Our Ref: **R/4/13/A**
Your Ref:

Town & Country Planning (Control of Advertisement) (England) Regulations 2007 (as amended)
Application for Consent to Display an Advertisement(s)

Development 3 No non-illuminated wall mounted signage and 2 No non-illuminated signage

Location Unit A Rustington Retail Park New Road Rustington

CHQ.12.9647-PL18

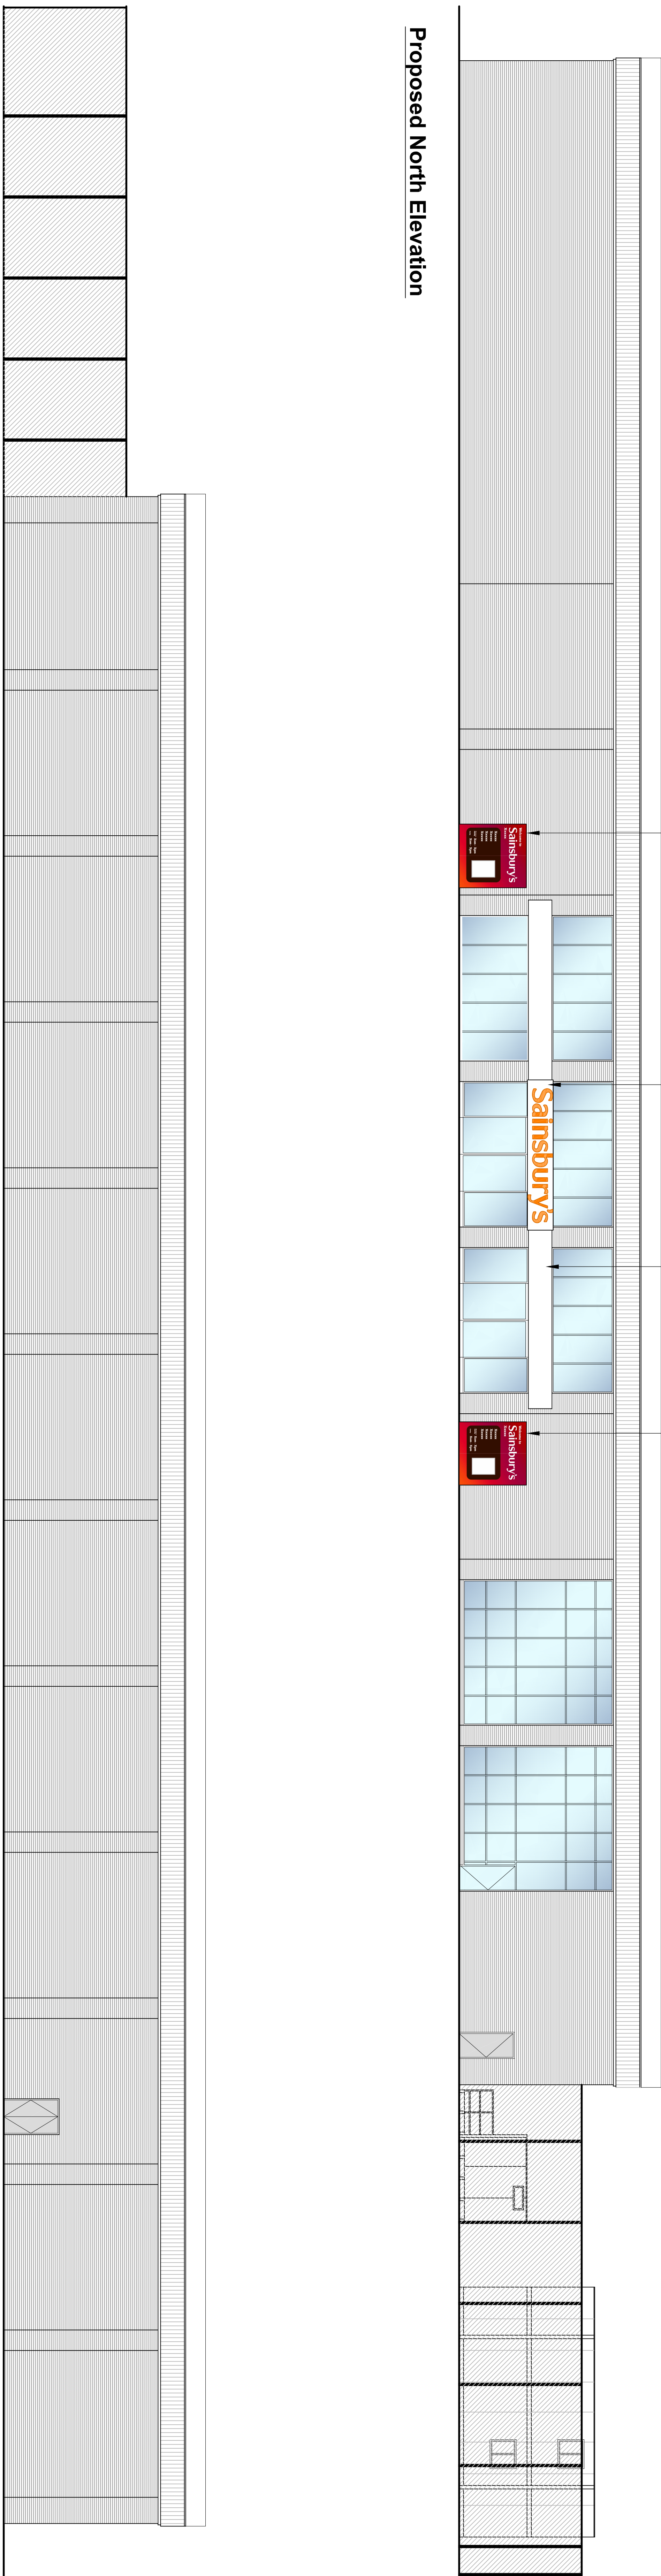
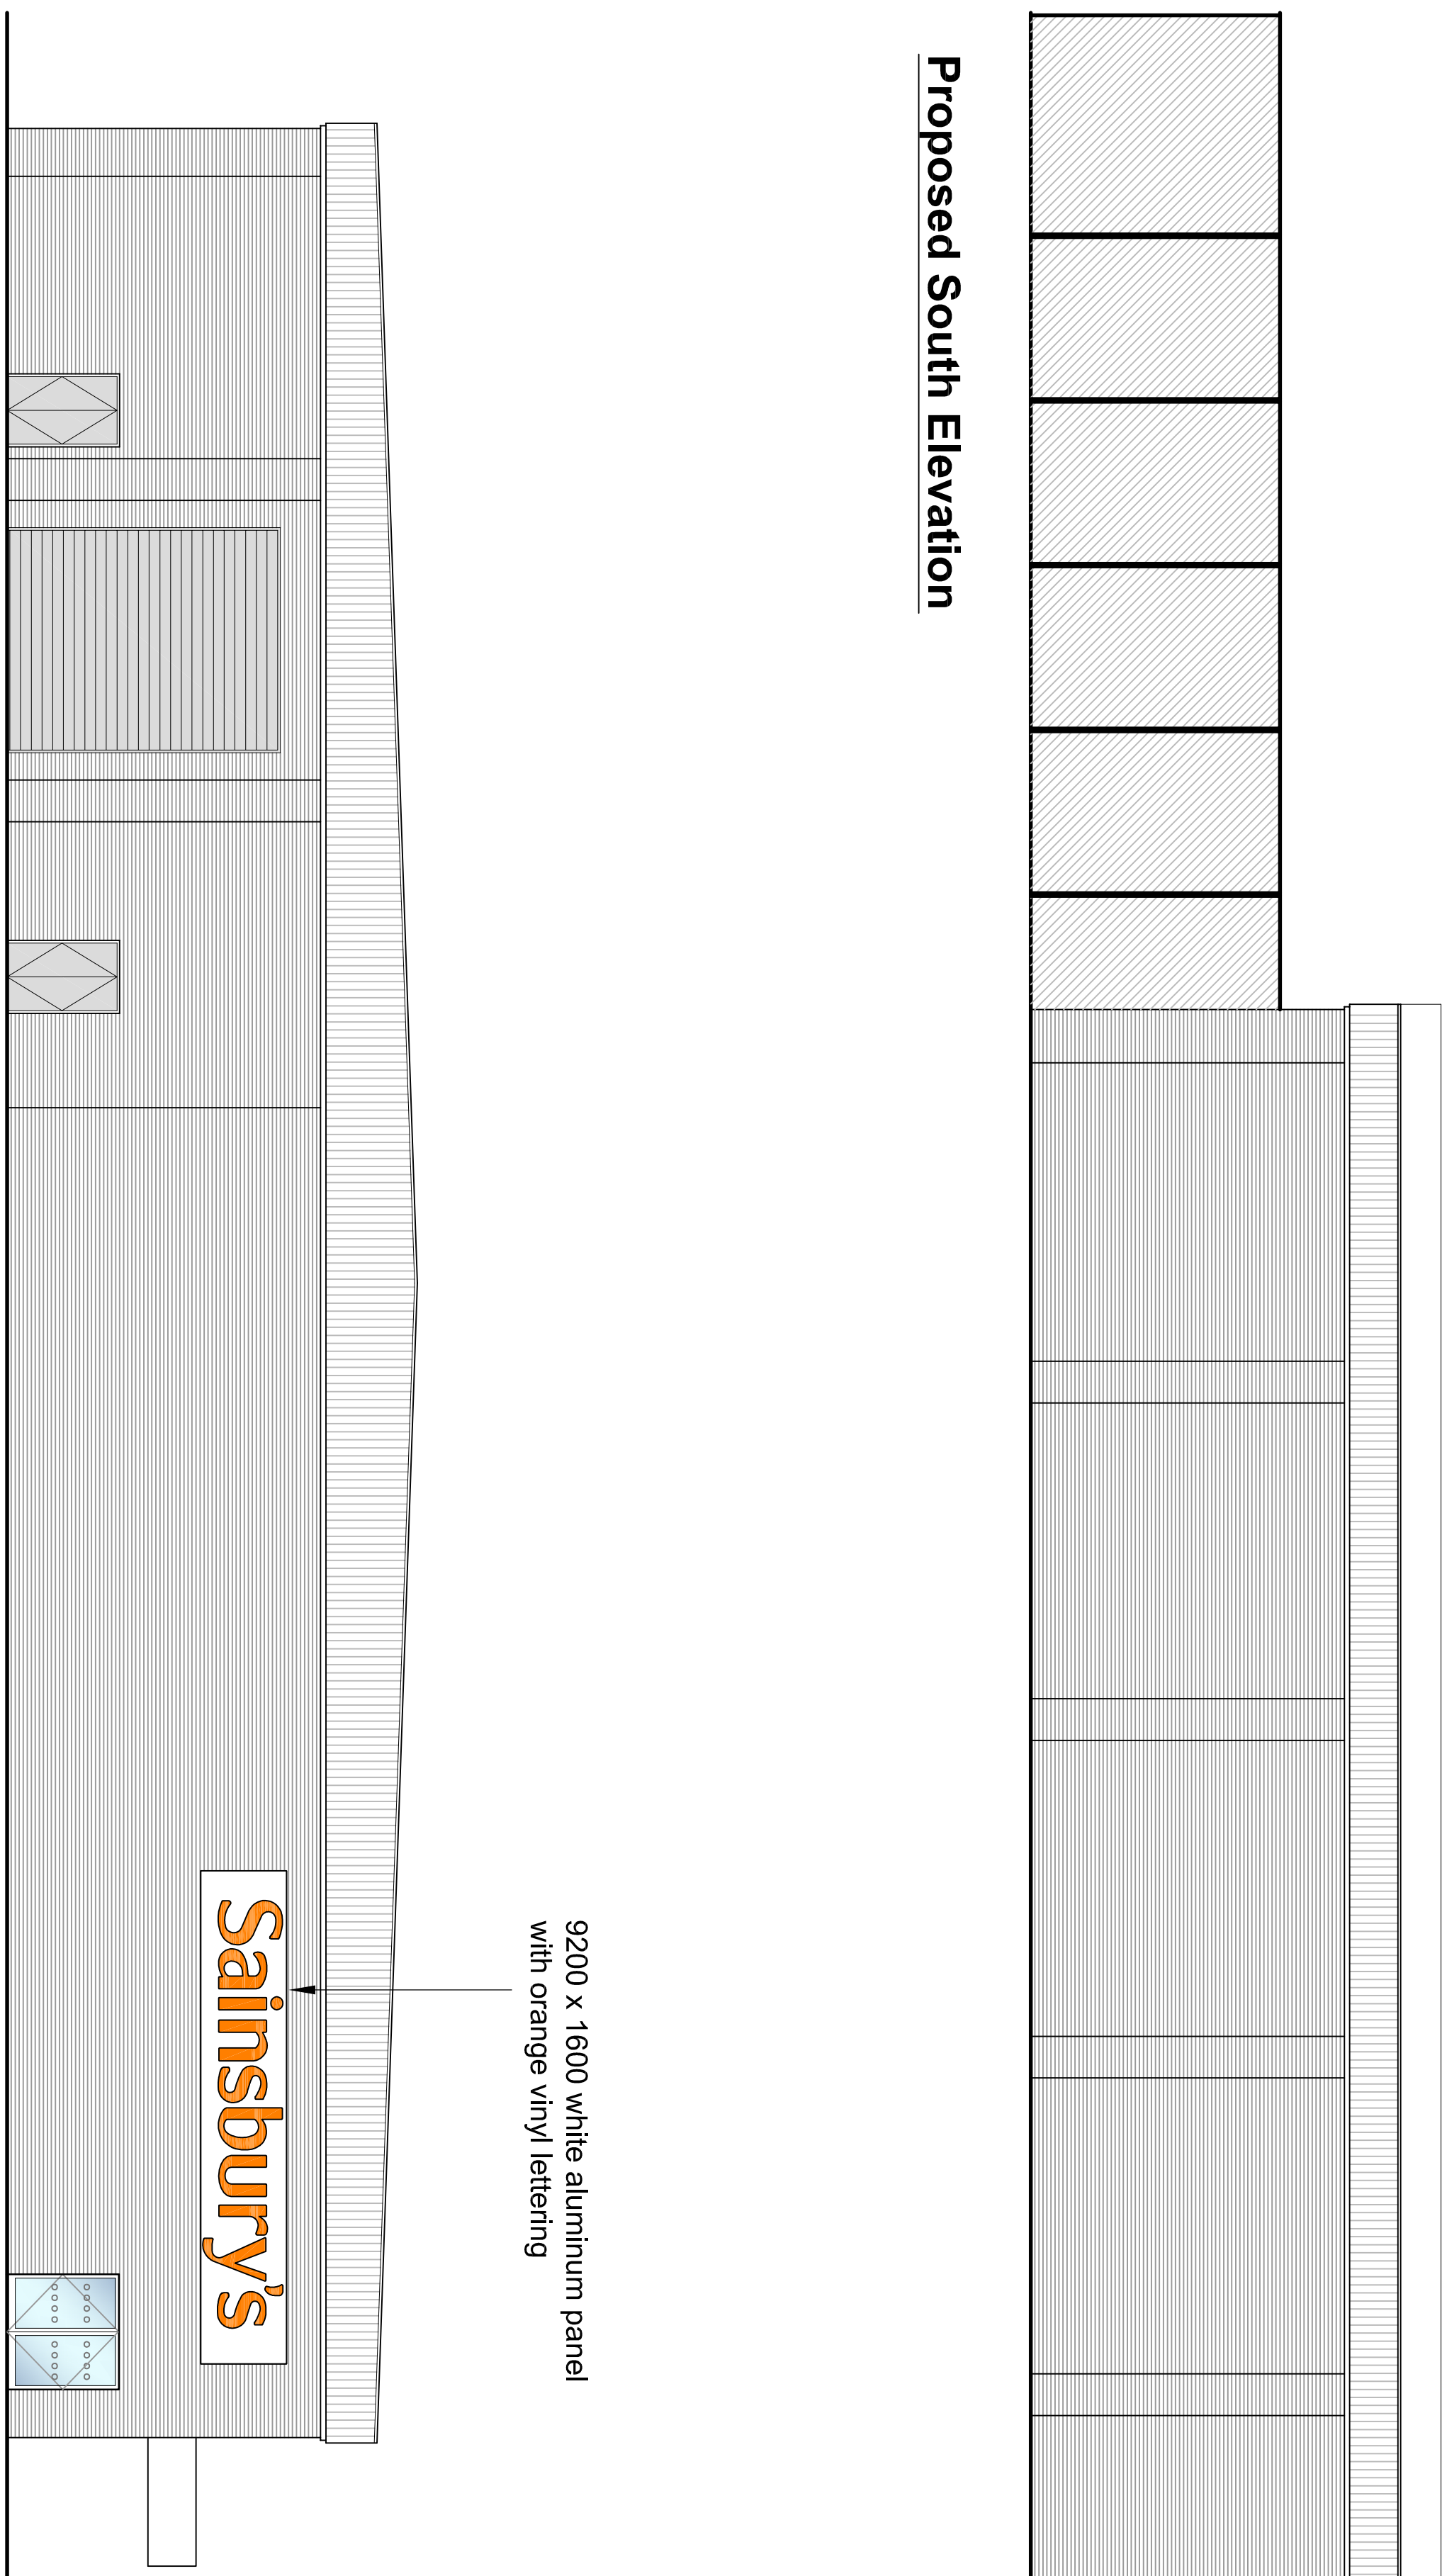
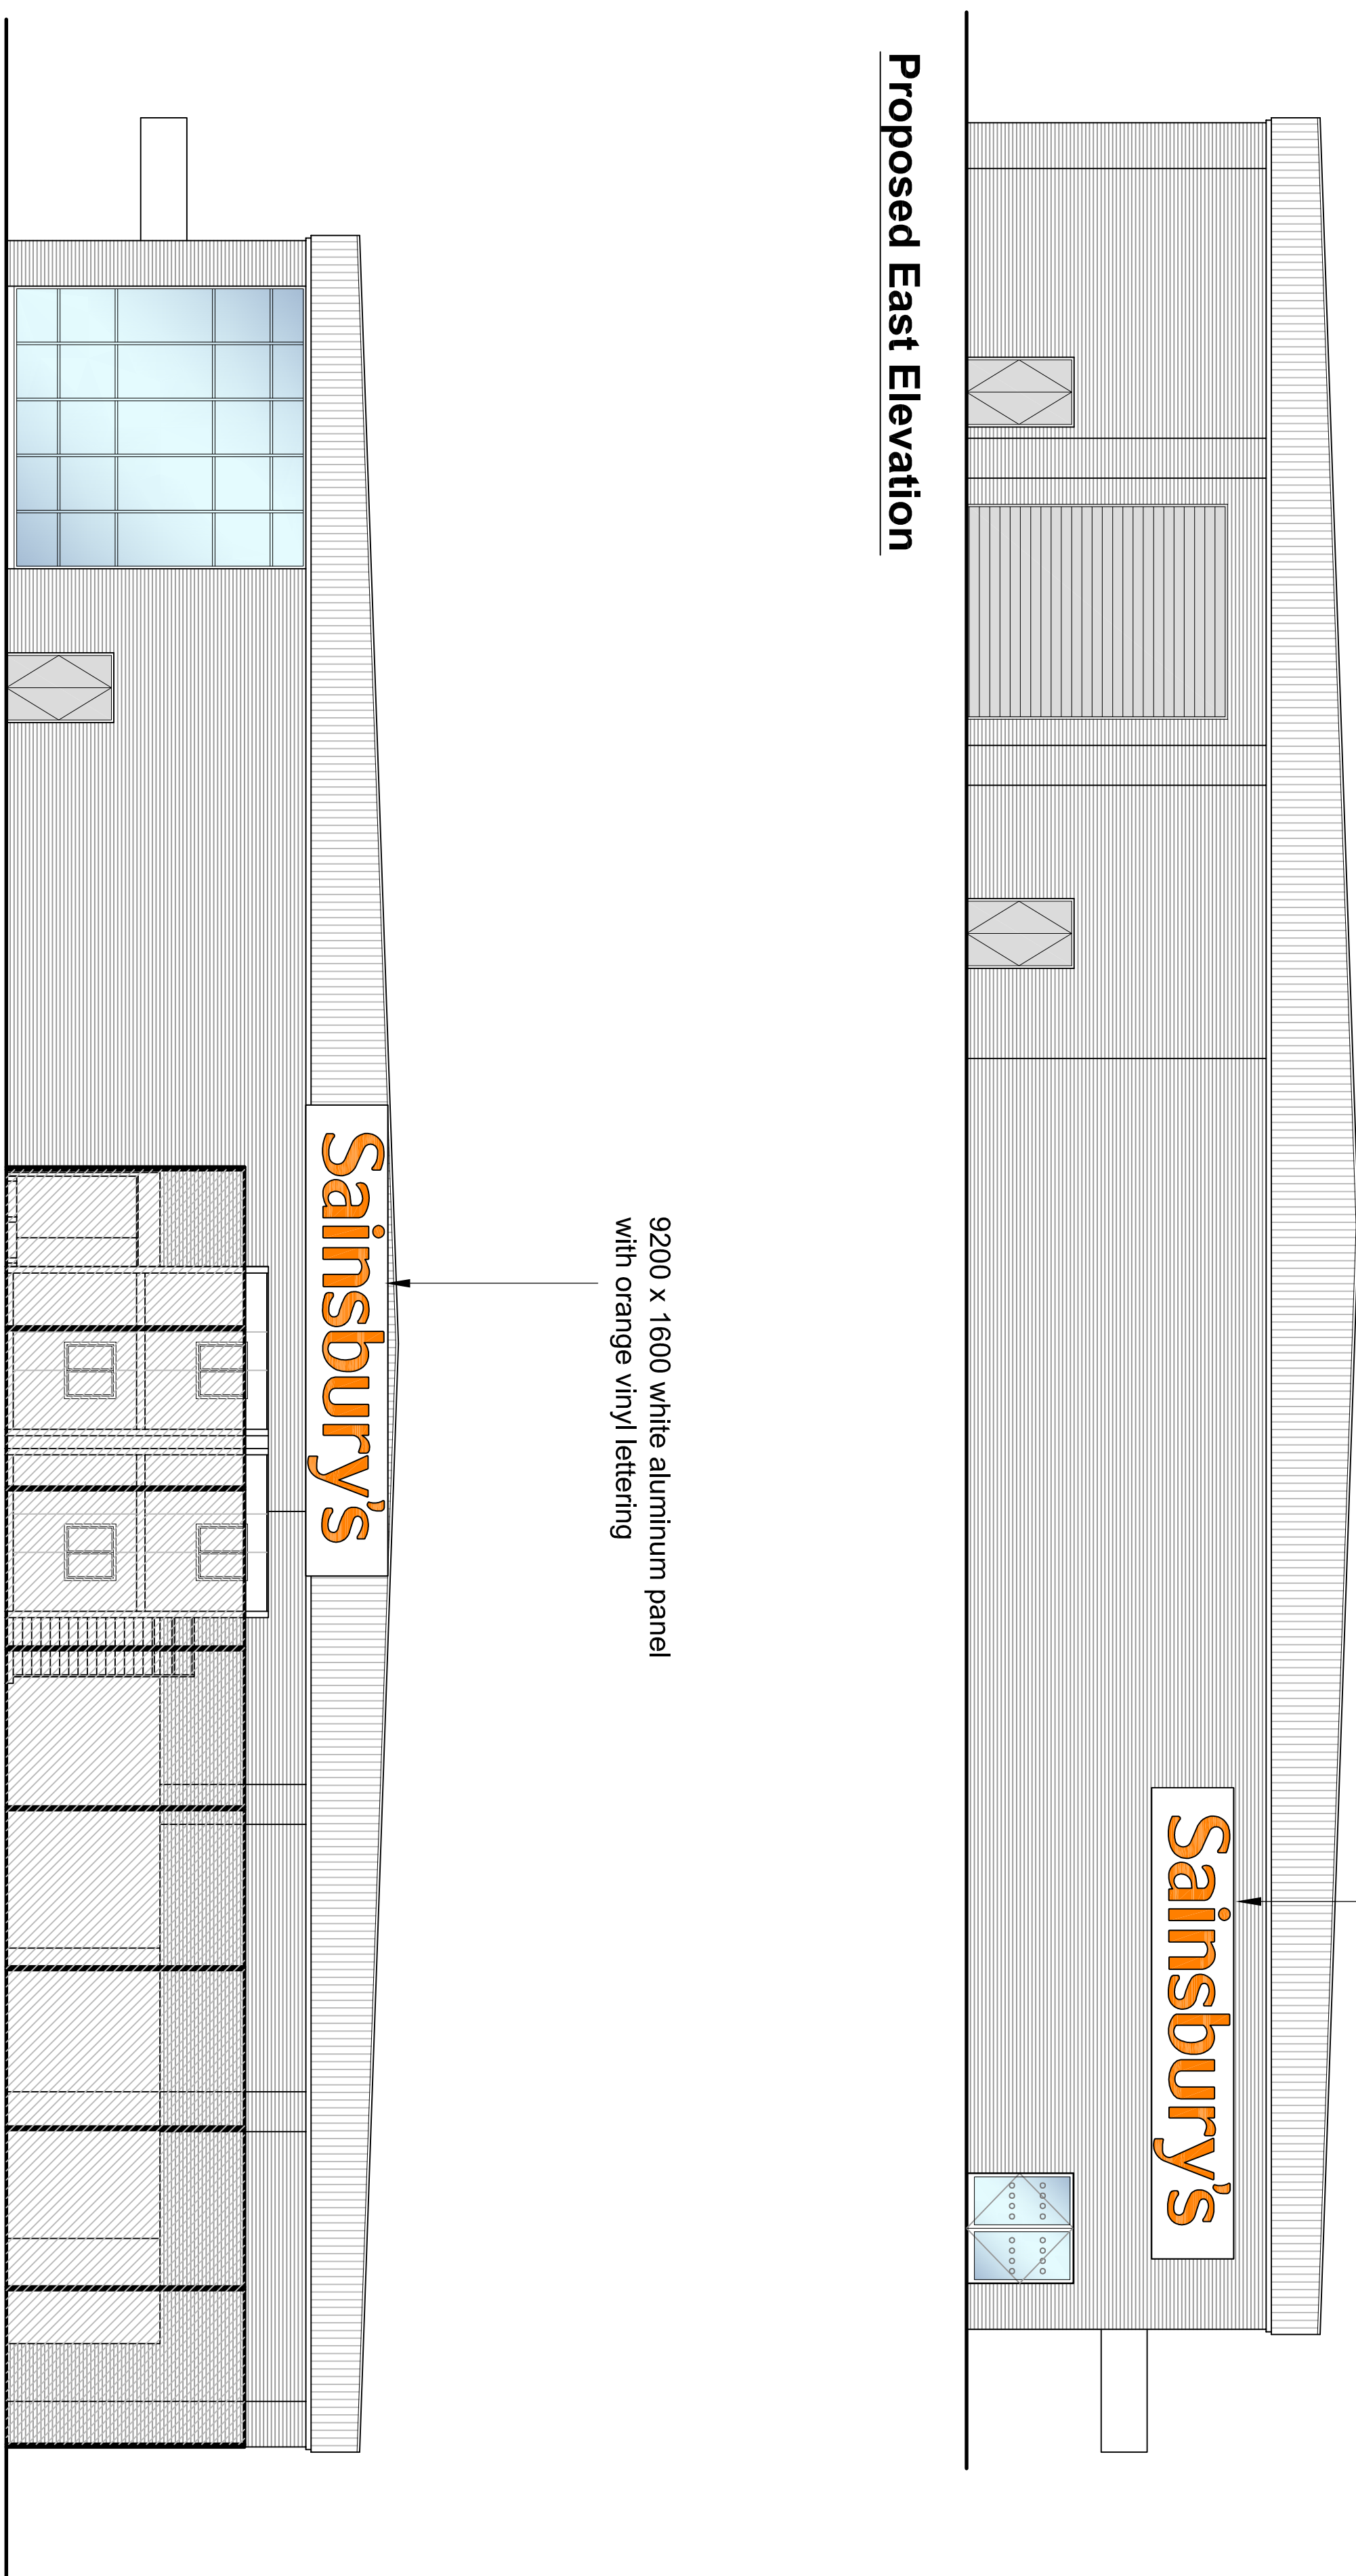
Please show the 2 No proposed Welcome signs on the floor plan on the Key Plan.

✗ Please confirm if you want to include the 2 No Totem signs in this application. If you are including these on the application, please show them on the Key Plan. *- do not include index*
